REPORT UPDATE

Application No: M/14/14/

Recommendation Report for Planning Permission

PROPOSAL: Replace 7 No wooden windows with PVCu to match existing style.

Technical drawings below showing cross sections of the Evolve VS window.

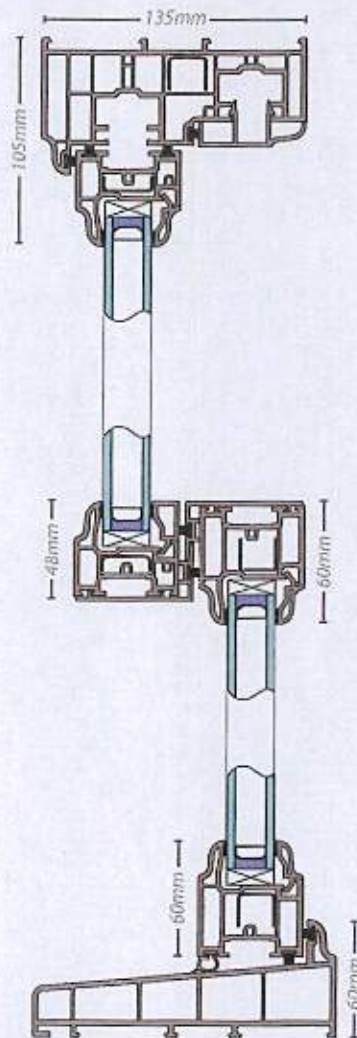
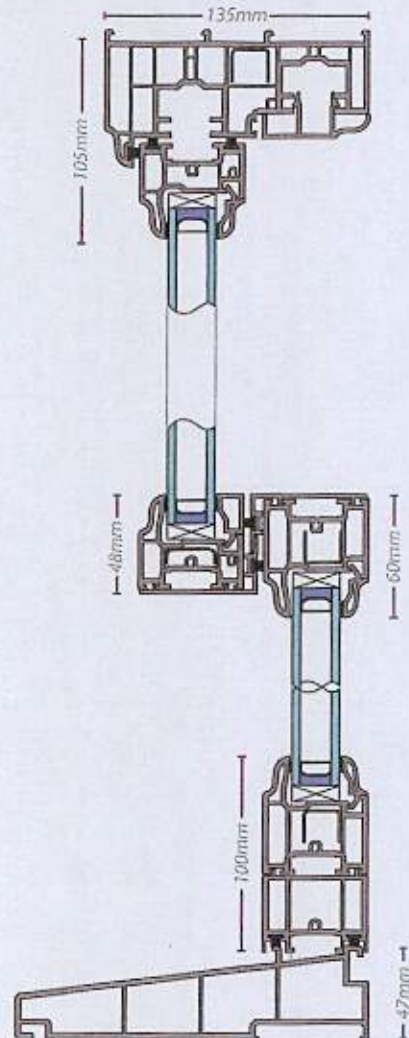
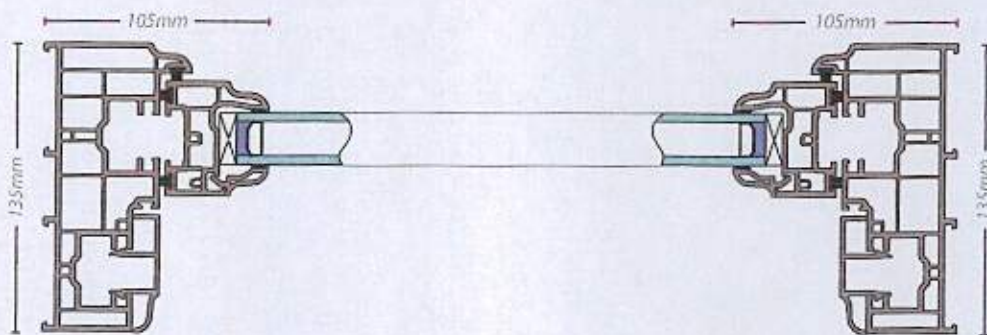
It is considered that the replacement plastic windows fail to match the appearance of the existing units: they will have larger, heavier sections than the existing timber windows and the black rubber gaskets will become visible around the glass. In addition, the method of opening is also in contrast to the existing which, as already mentioned is an inappropriate method for providing ventilation.

It is considered that the replacement plastic windows fail to match the appearance of the existing units: they will have larger, heavier sections than the existing timber windows and the black rubber gaskets will become visible around the glass.

- 1 The replacement windows by reason of the materials to be used, the depth of the reveals and their proportions would detract from the visual quality of the building and character and appearance of the area in conflict with policy GEN7 of the Arun District Local Plan, policies DDM1 and DDM4 of the Emerging Local Plan and the National Planning Policy Framework.
